**El Paso County
Planning & Community Development**
2880 International Circle, Suite 110
Colorado Springs, CO 80910-3127
Attn: Len Kendall

August 28, 2018

**RE: Woodmen Hills Metropolitan District
Lift Station #1 Replacement
Administrative Plot Plan – Drainage Letter**
Please add street address in the title.

D PERMEABLE PAVER - SECTION
SCALE: N.T.S.

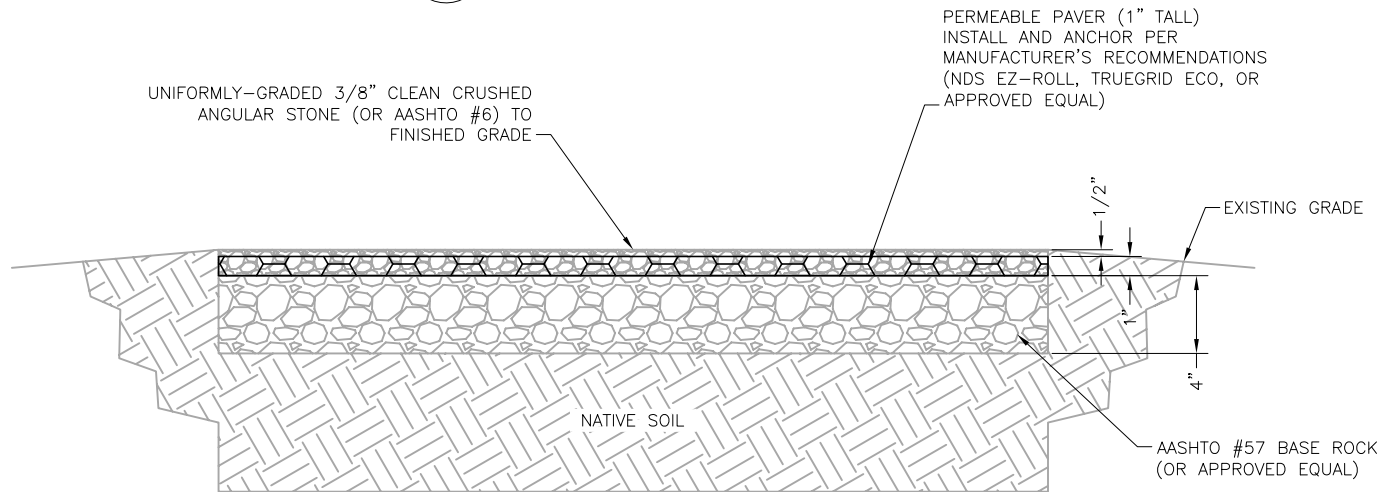
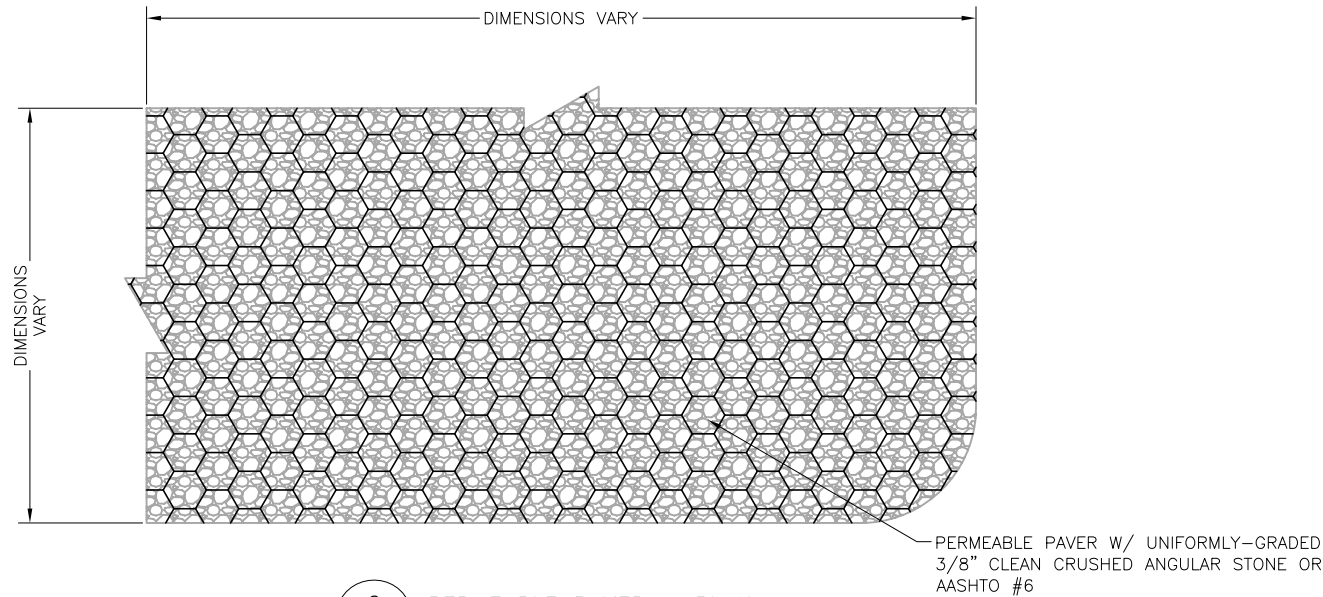
Although the disturbance of the site is less than acre (therefore water quality is not necessary) you are providing water quality for the site. Please quantify the capture volume of for the permeable pavement system.

C13

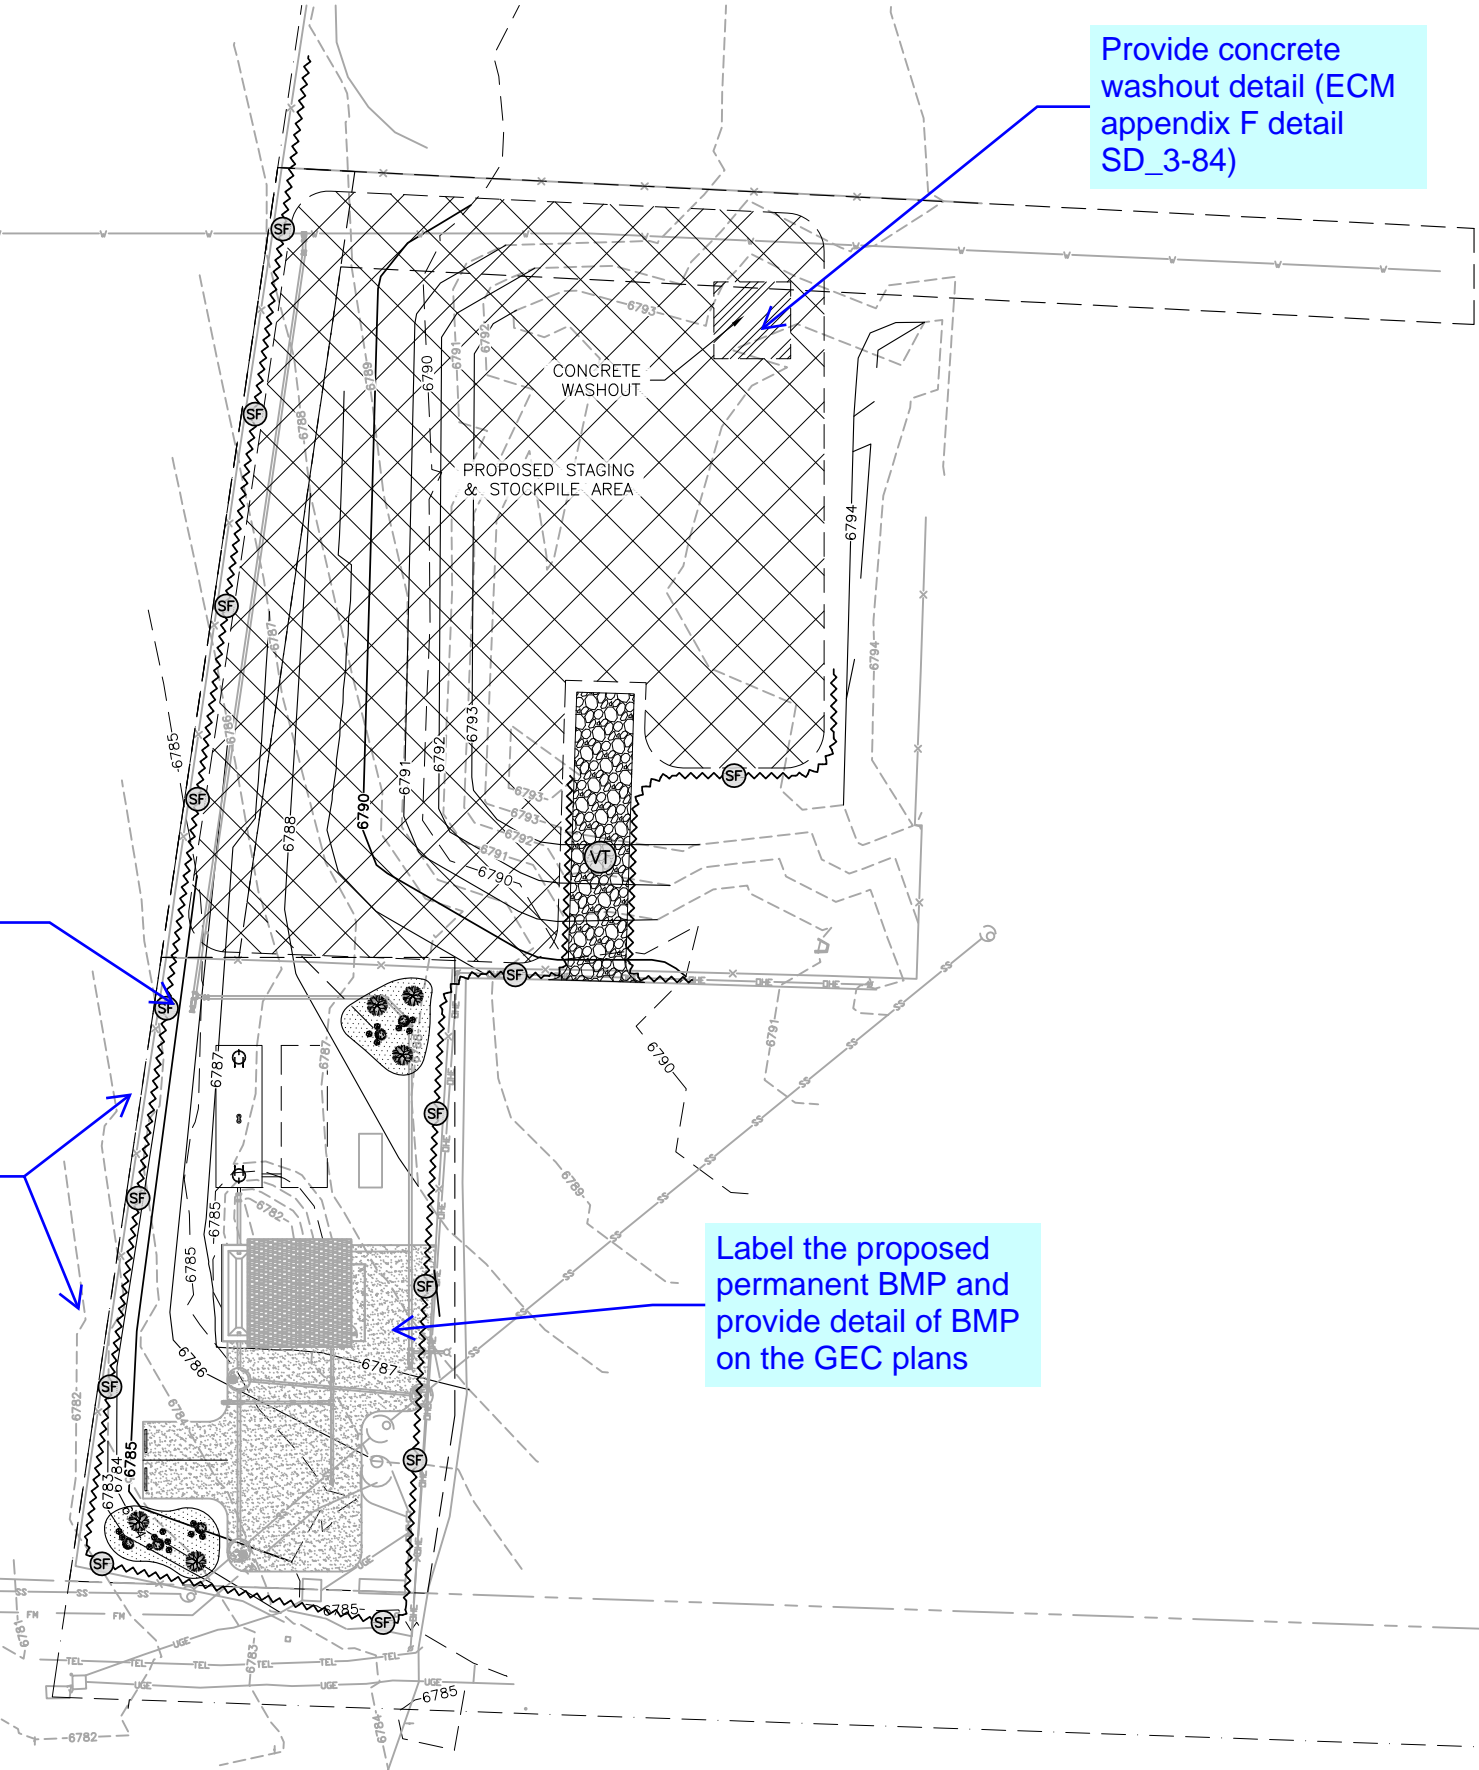
There is an existing pond shown on the GEC that is to be filled. What is its current use and how did it get there. Address this in your report.
